Sent: 28 October 2025 19:37
To: Louise Bearcroft <Louise.Bearcroft@kirklees.gov.uk>; DC Admin <DC.Admin@kirklees.gov.uk>
Subject: Objection

Re: Kirklees Planning Applications: 2025/44/92737/E and 2025/61/92713/E

Site address: Rear of, 23 to 43, Moor Lane, Gomersal, Cleckheaton, BD19 4LF

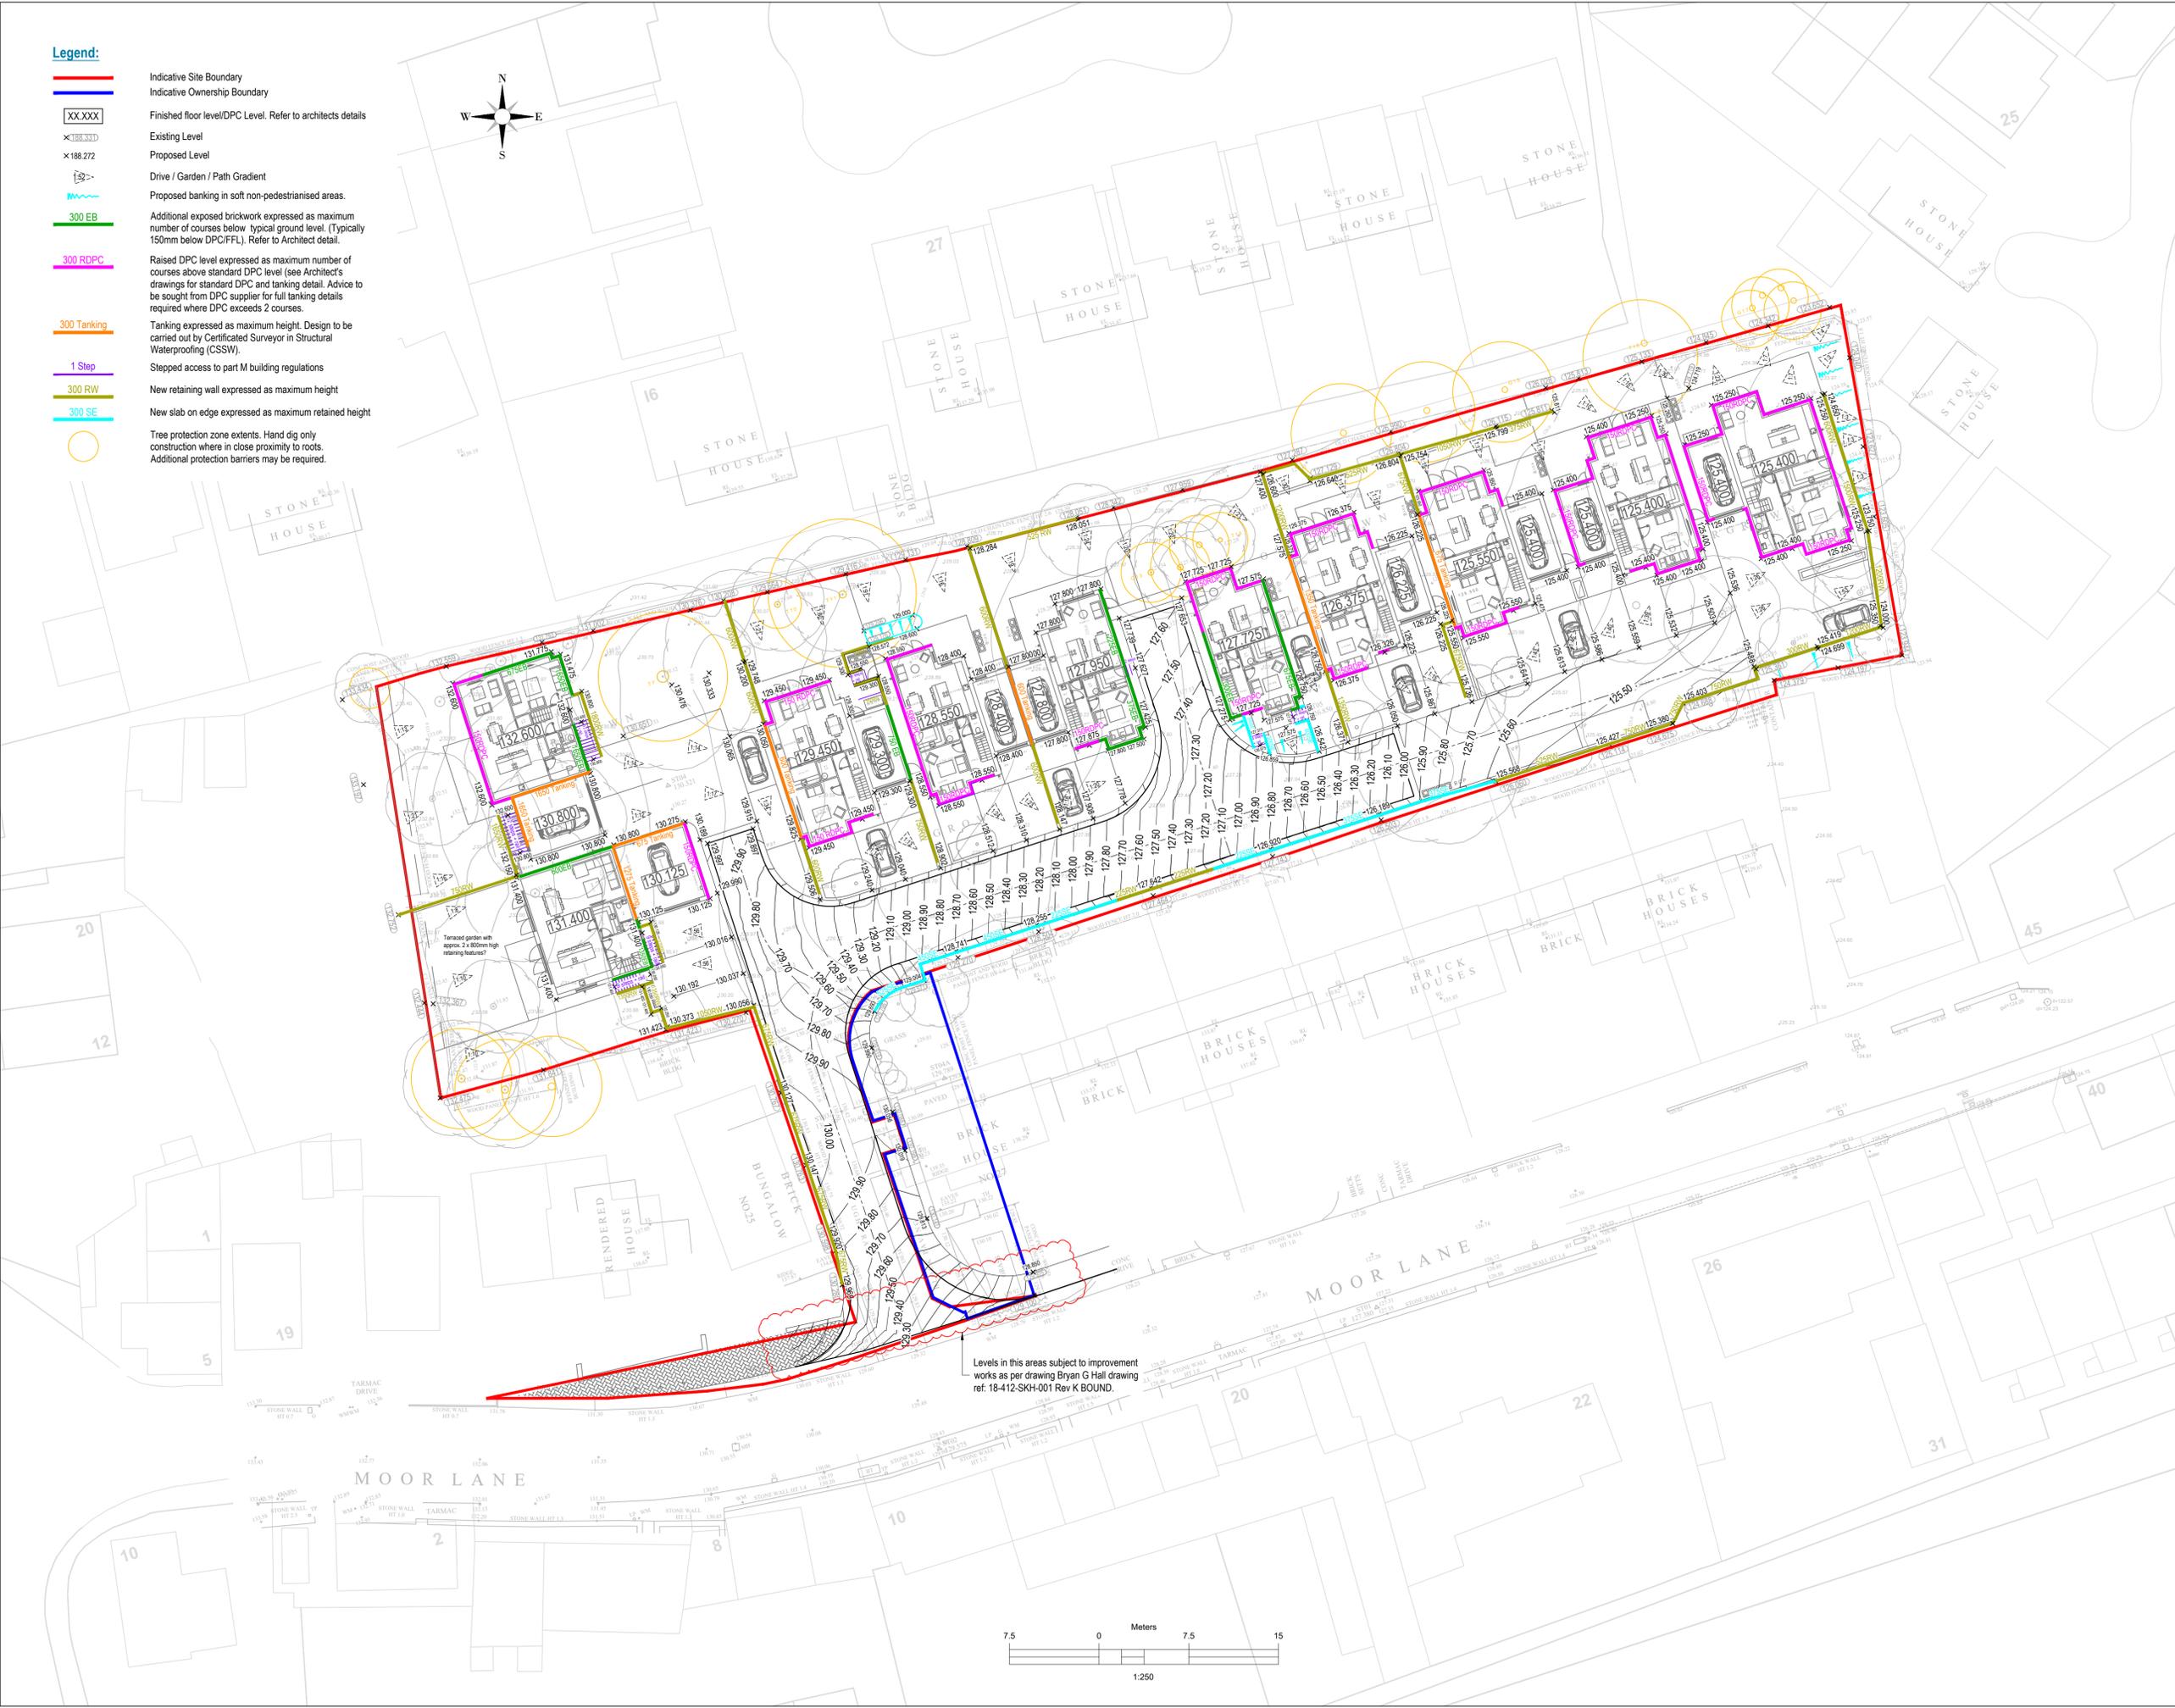
If the drainage plans are up to the required standard, then why does the developer feel it is necessary to ‘Tank’ certain walls on these new build houses? 6 out of the 10 proposed houses, at the top end of the site, are shown, on the Levels Plan, as being built having tanking installed. As these new build houses are all above ground level, why is tanking being used to stop water ingress to make them waterproof? Tanking is normally used in wet and damp cellars and very old buildings, generally not on new builds. If tanking is deemed necessary, then this seems to confirm that surface water is going to be a problem and logically it’s going to flow downhill and across the site following the gradients.
